DEVELOPMENT REVIEW BOARD  
SUPPLEMENTAL SUBMITTAL

PROJECT NO. PR-2021-006258  
Application No. SD-2022-00005

SUBMITTAL DESCRIPTION: Revised plat to remove AMAFCA agreements, added cross-lot drainage easement, and revised purpose of plat to include granting an easement. Updated letter to DRB addresses plat comments from 2/2/22 Final Plat hearing.

**Re: Final Plat Review for Proposed Tract A-2-A-1, Journal Center Phase 2, Unit 2 being comprised of Remaining Portions of Tracts A-2-A and A-3-A of Journal Center Phase 2, Unit 2**

Line Table

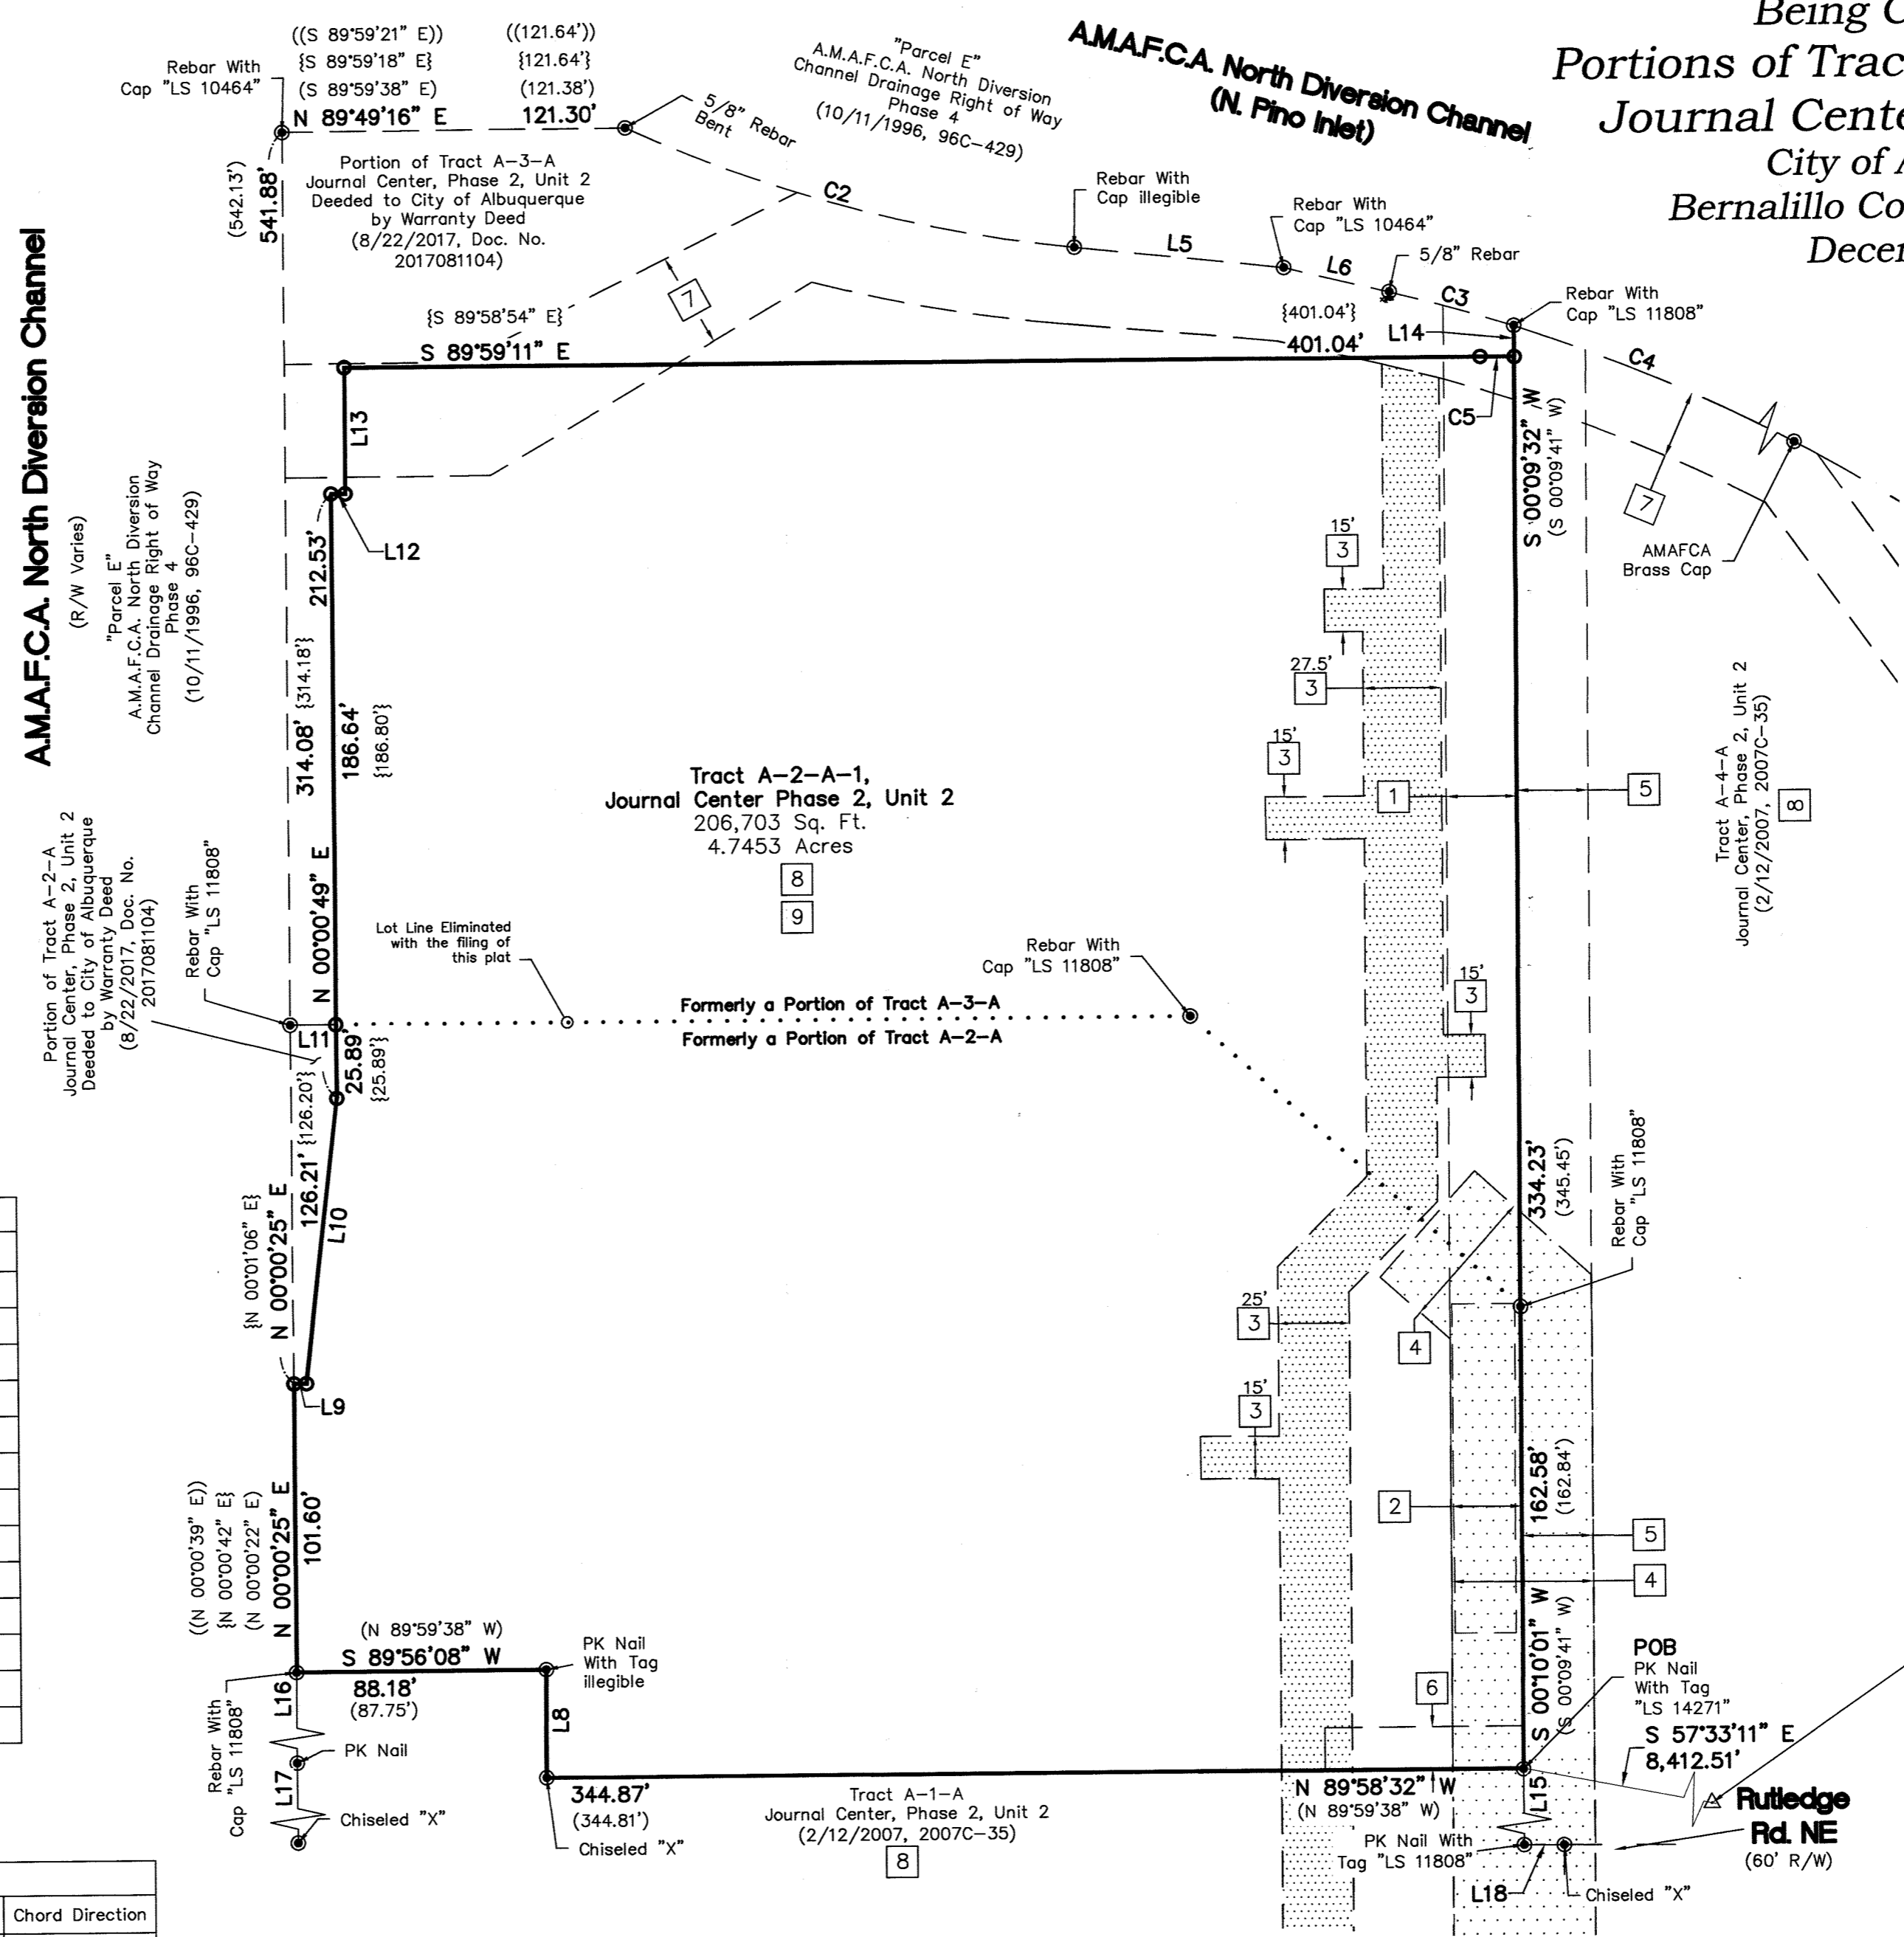
Add a Cross Lot Drainage Easement note specifying the beneficiary and maintenance agreement. (this will be for that offsite drainage that goes through this lot)

• Easement Notes 9 & 10 – **These two items are not Drainage Easements** but recorded COA Drainage Covenants. **Please remove these items from the plat.** These two Drainage Covenants need to be vacated. Please Marion G. Velasquez (mgvelasquez@cabq.gov) on the 4th floor of Plaza de Sol for instructions.

Noted, cross-lot drainage easement has been added to the plat as easement [9].

Noted, AMAFCA was contacted on December 2<sup>nd</sup> and their comments are provided below. We have removed the easement notes for these agreements, and documents were prepared for their release between our client and AMAFCA.
